Reference – PP-07331936 Decoy Farm, Crowland

This letter accompanies a planning application for a non-material amendment that is sought in relation to the solar farm approved and installed at Decoy Farm, Crowland under planning permission ref H02-0454-14. The amendments sought are all considered minor and not deemed material to the overall scheme. The amendments that are sought are as follows;

15/PA003E

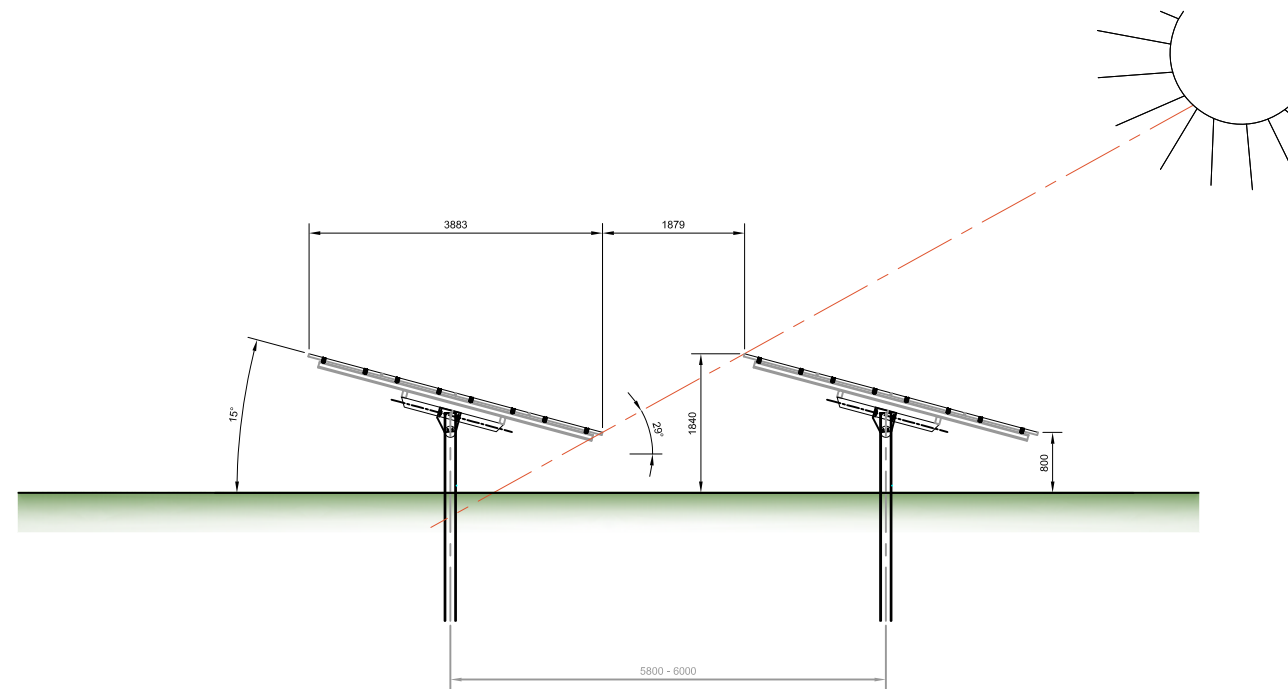
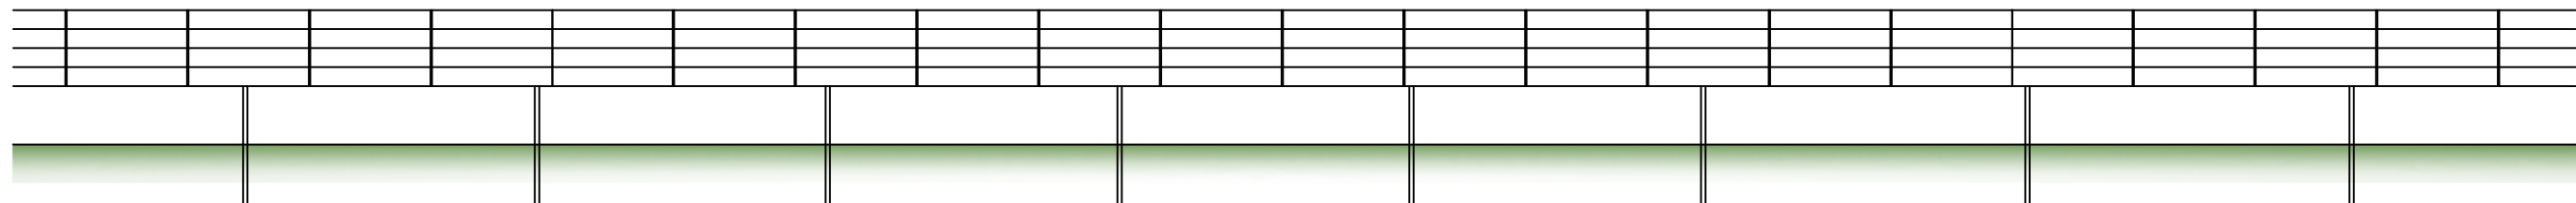
- Update drawing PA203 to include elevations of HV switchgear housing rather than the previous elevations of the comms cabinet;
- Revision of overflow tank location on site layout plan to ensure compliance;
- Amending elevations of Pad Mount Transformer;
- Update drawing PA010 to relocate a single door on approved Comms Cabinet; and
- Updating the mounting system plan to ensure compliance.
